CITY OF ALBUQUERQUE

July 28, 2025

RE: 10120 Coors Blvd NW
Grading and Drainage Plans
Engineer's Stamp Date: 7/8/25
Hydrology File: B14D013
Case # HYDR-2025-00252

GRADING DETAILS

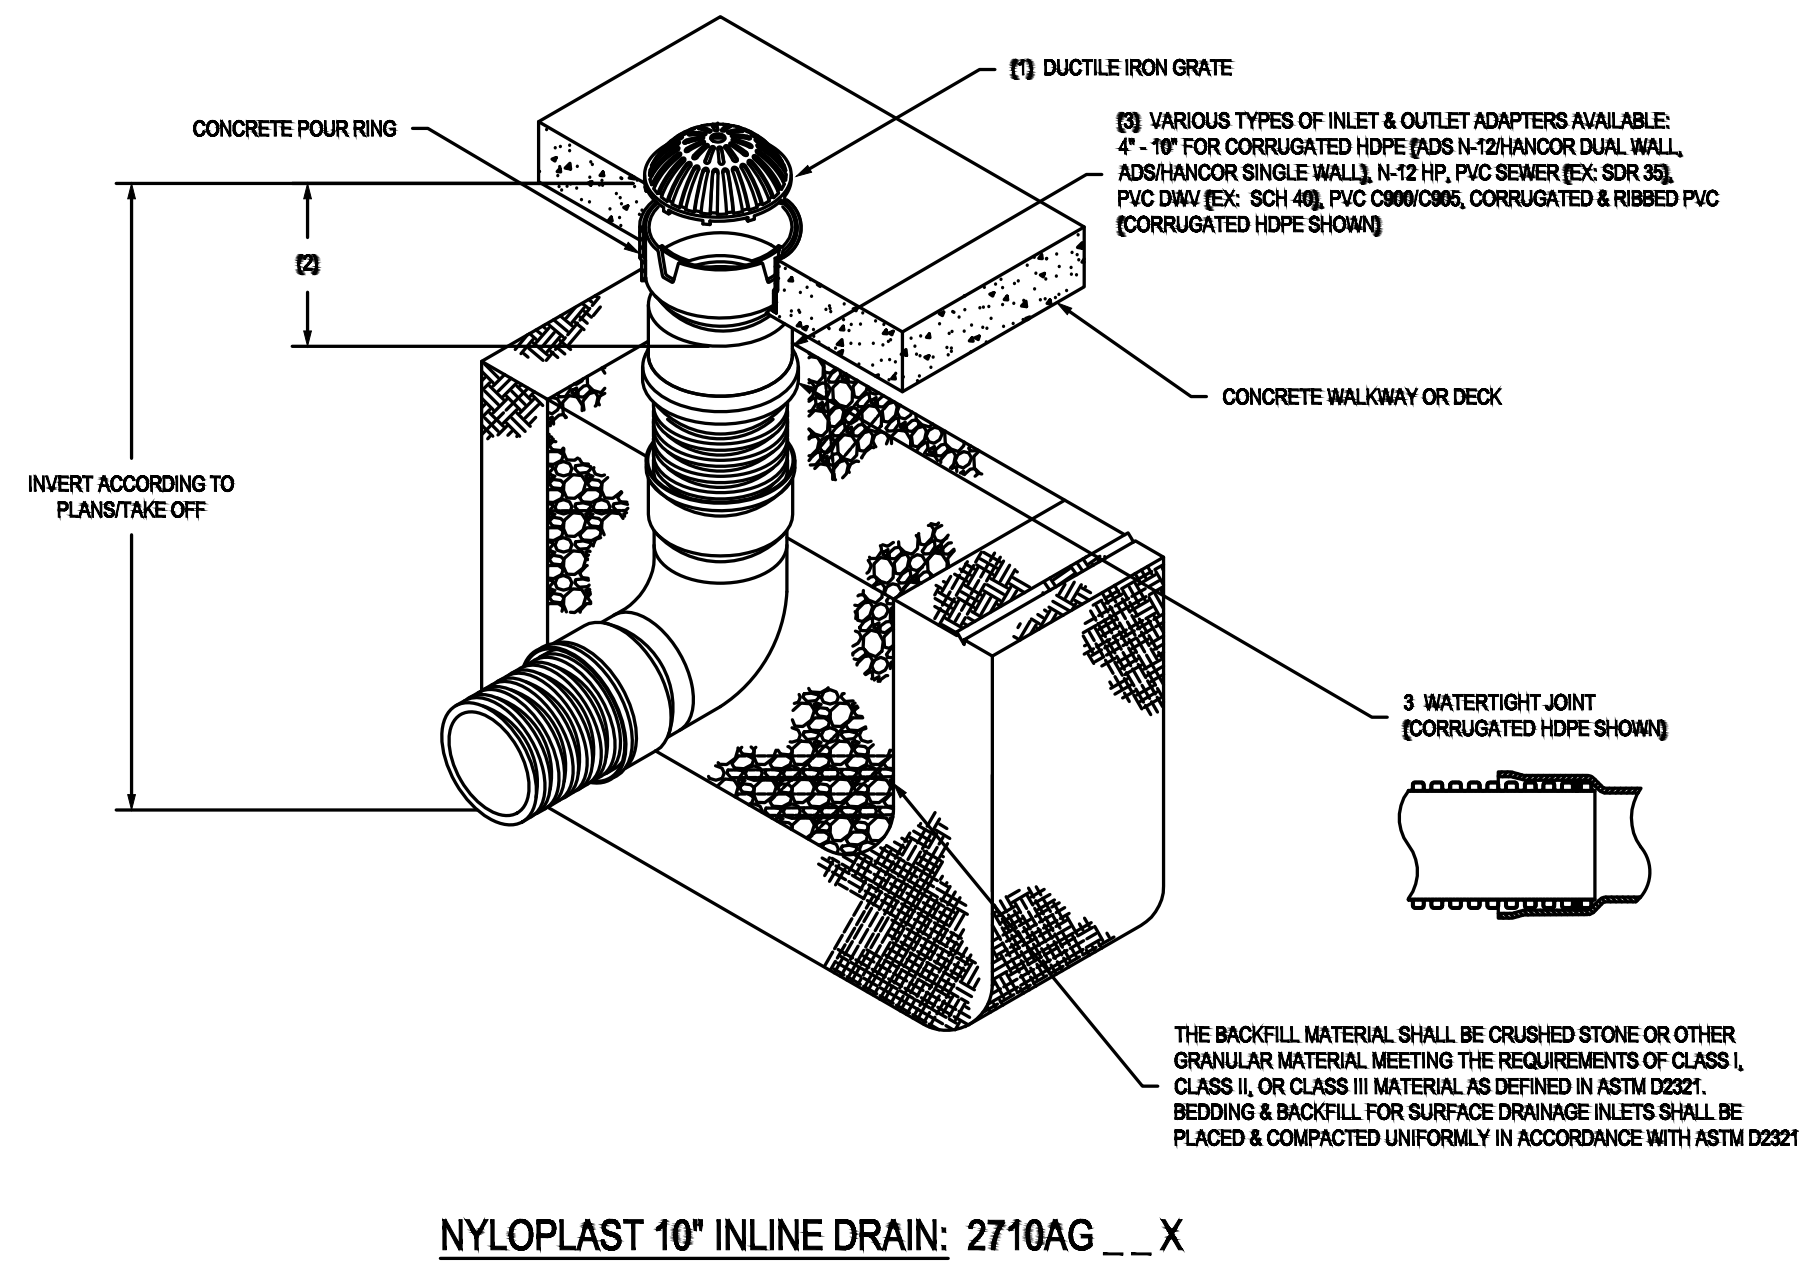
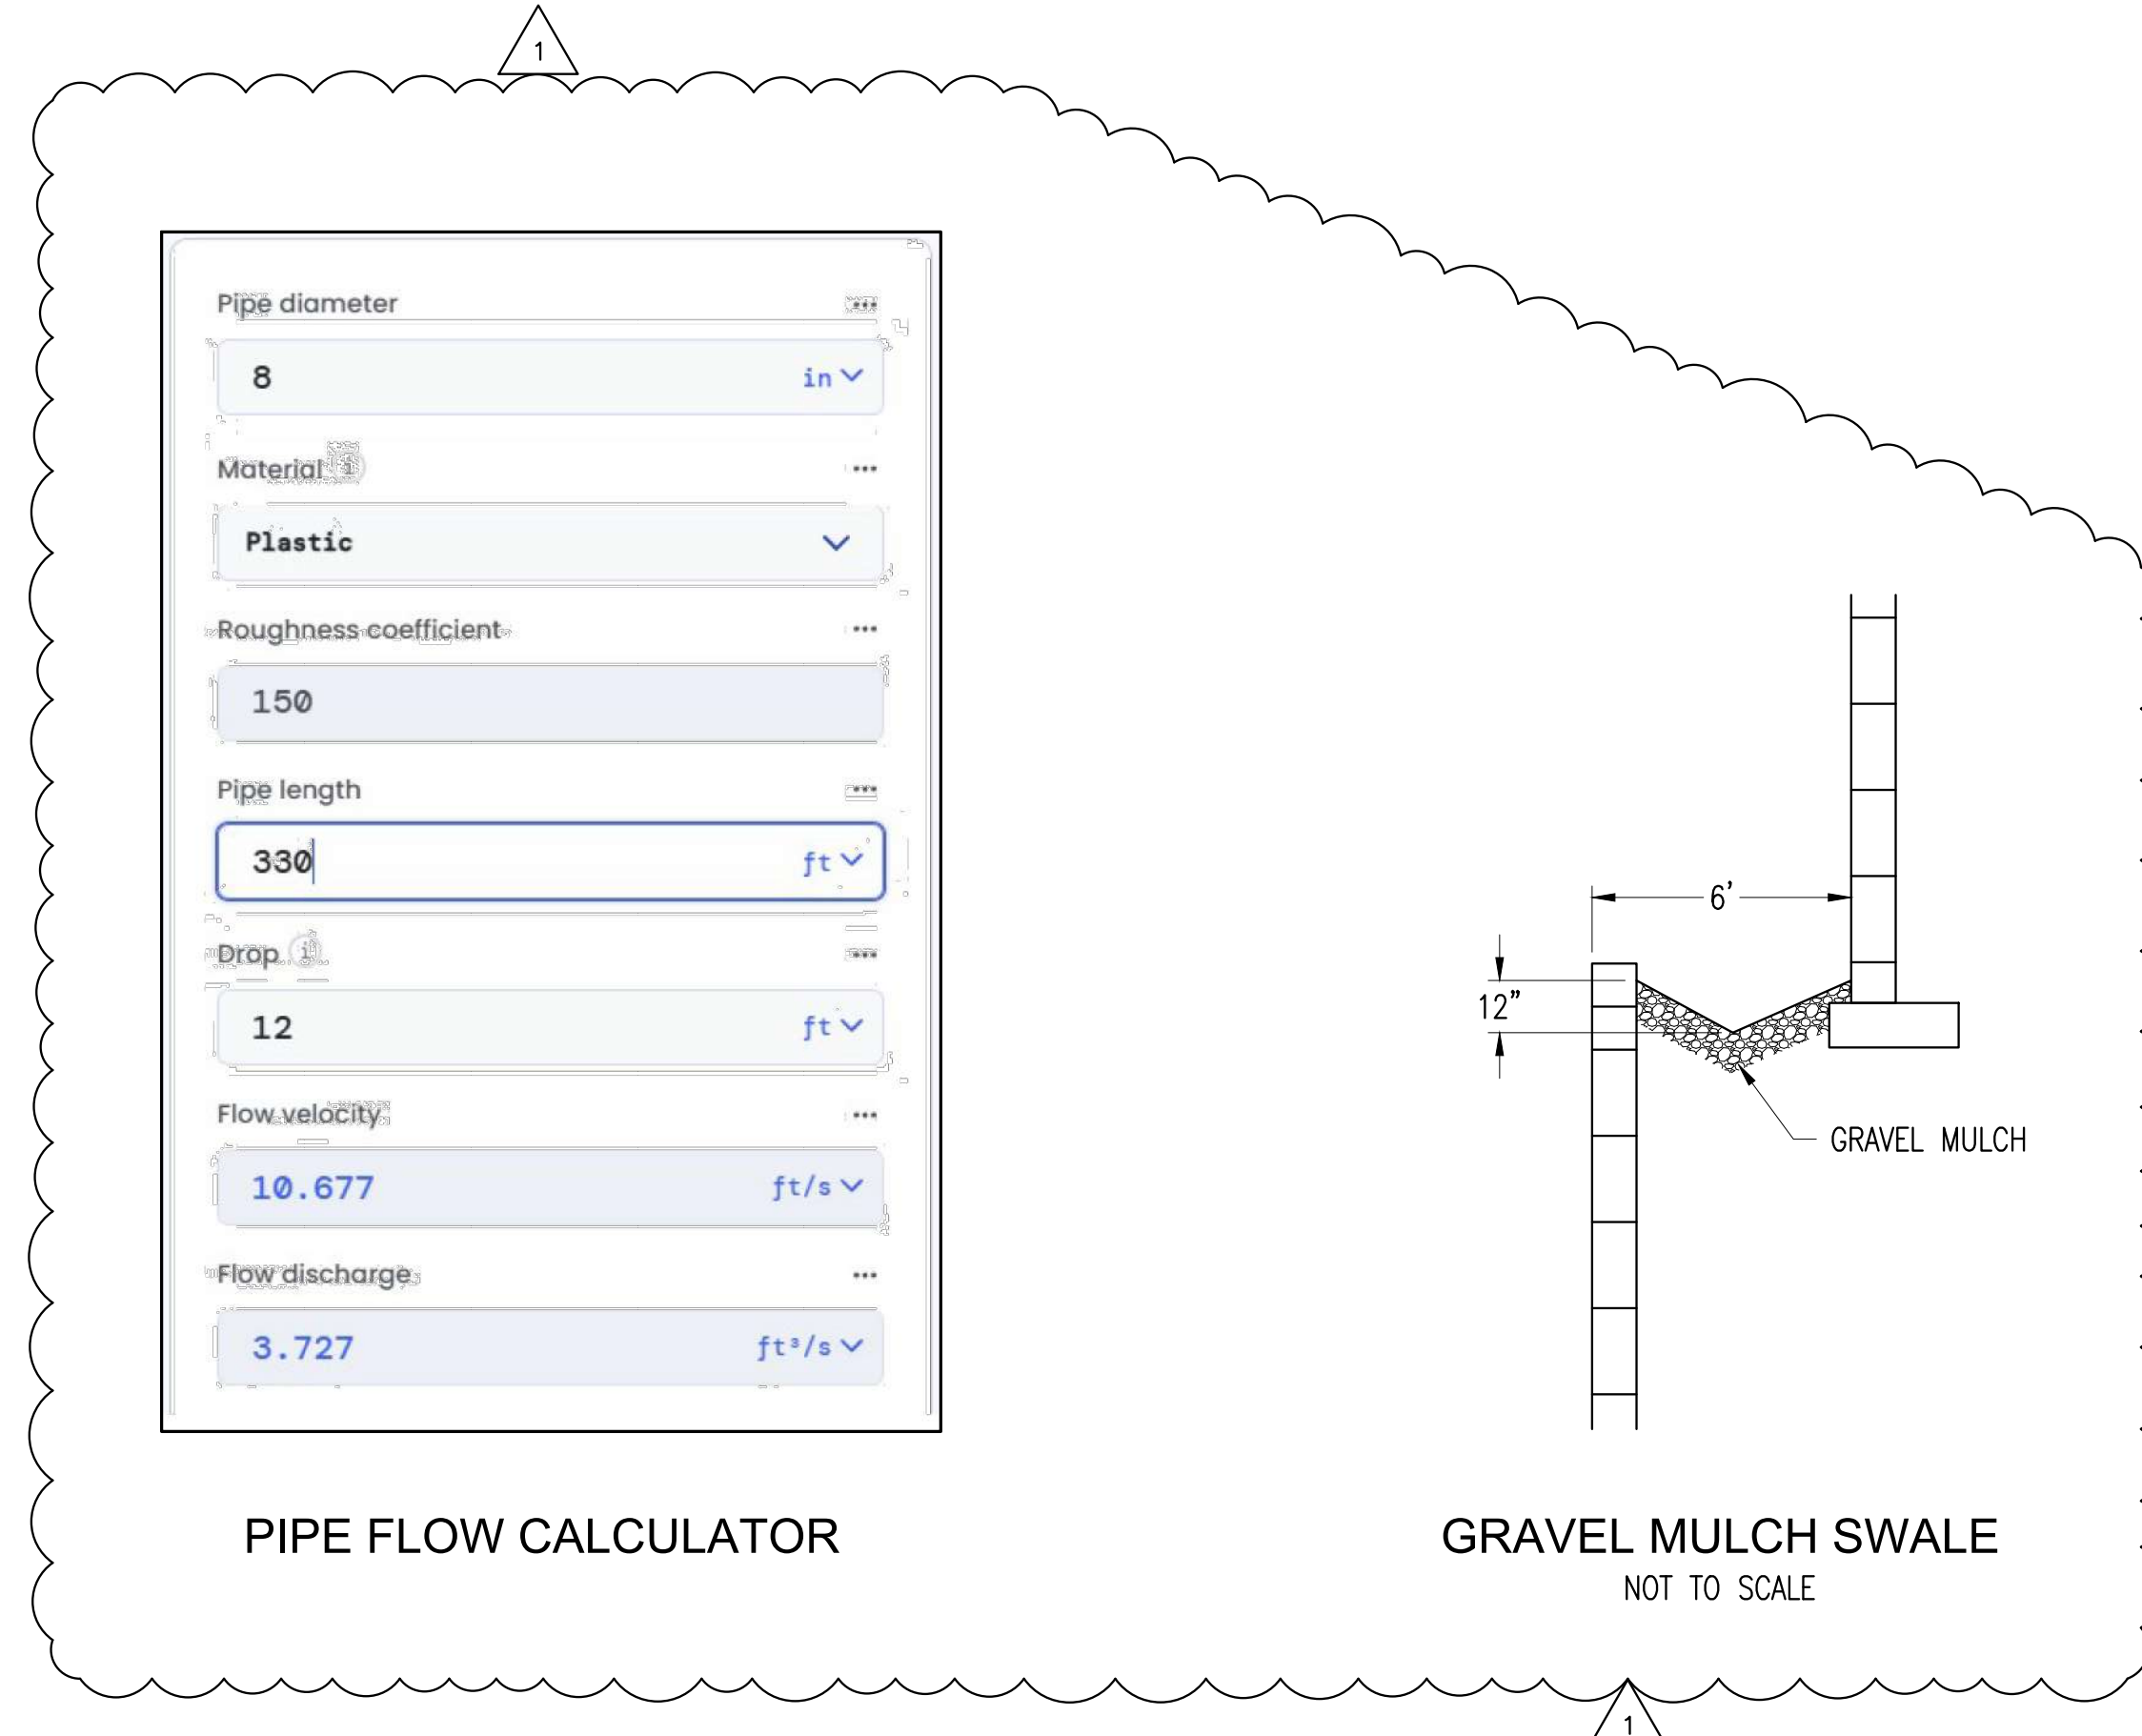
1. Please provide the FIRM Map for this site.
2. Is the 48" storm drain line to be extended through the Work Order process?
3. Show profile of 48" and the other storm drain lines.
4. Identify ownership of the storm drain lines.
5. Show the property lines for this lot.
6. Show the Finished Pad elevations in addition to the Finished Floor elevations.
7. Label the 200CF Basin C Pond.
8. Since this project is adjacent to, or drains into an Albuquerque Metropolitan Arroyo and Flood Control Authority (AMAFCA) facility, approval by AMAFCA will be need prior to Hydrology approval. Please contact Jared Romero P.E, CFM (jromero@amafca.org or 505-884-2215).
